Ribble Valley Borough Council
Council Offices
Church Walk,
Clitheroe
Lancashire
BB7 2RA

Phone: 0300 123 6780
Email: Kathryn.Walsh@lancashire.gov.uk
Your ref: 3/2025/0189
Our ref: 3/2025/0189/HDC/KW
Date: 29 April 2025

Location: Moorcock House Slaidburn Road Waddington BB7 3AA
Proposal: Demolition of existing 4 bedroom dwelling and construction of replacement 6 bedroom dwelling with integral garage.
Grid Ref: 371810 446661

Proposed Site Plan
Scale (1:500)

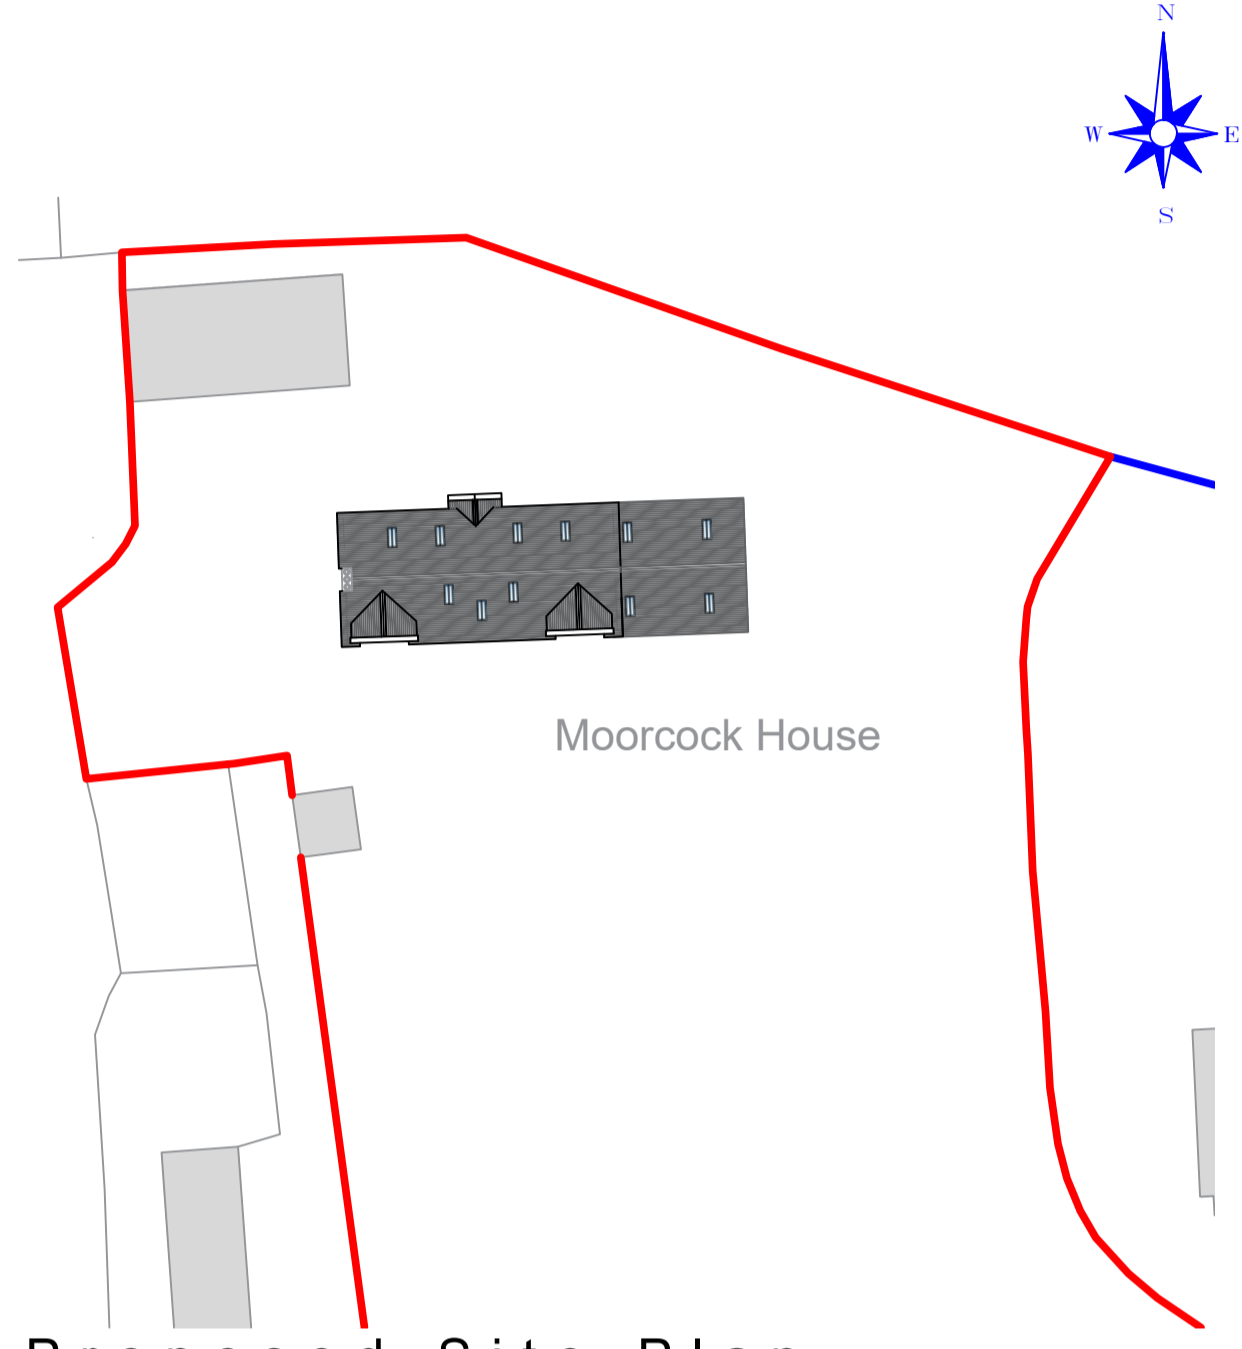
The LHA have reviewed the proposed site plan within drawing number 006 Revision C. and are aware that the proposal will retain the existing access road and parking area as well as create an integrated garage. The recommended minimum internal dimensions for a single garage size is 6m in length and 3m wide. The proposed garage measures approximately 7.6m long and 5.8m wide, and as such will support parking provisions for at least 1 vehicle. The proposal meets the parking standard for a 6 bedroom dwelling as defined in the Joint Lancashire Structure Plan. Therefore, the LHA have no objection to the proposal.

The site shall increase its sustainable transport options to encourage and promote sustainable transport use. Therefore, the development shall include covered secure cycle storage to ensure the provision and availability of adequate cycle parking for each resident and the promotion of sustainable forms of transport, which can be catered for within the proposed garage.

Additionally, due to the nature of the application, it is expected that a charging point for electric vehicles is included in the development to promote sustainable modes of transport. The DfT guidance regarding Electric Vehicle Charging in Residential and Non-residential buildings states charge points must have a minimum power rating output of 7kW and be fitted with a universal socket that can charge all types of electric vehicles.

1. The development hereby permitted shall not be occupied until the car parking and turning areas have been provided in full and are available for use. The car parking and turning areas shall thereafter be kept available for the parking and manoeuvring of vehicles at all times.
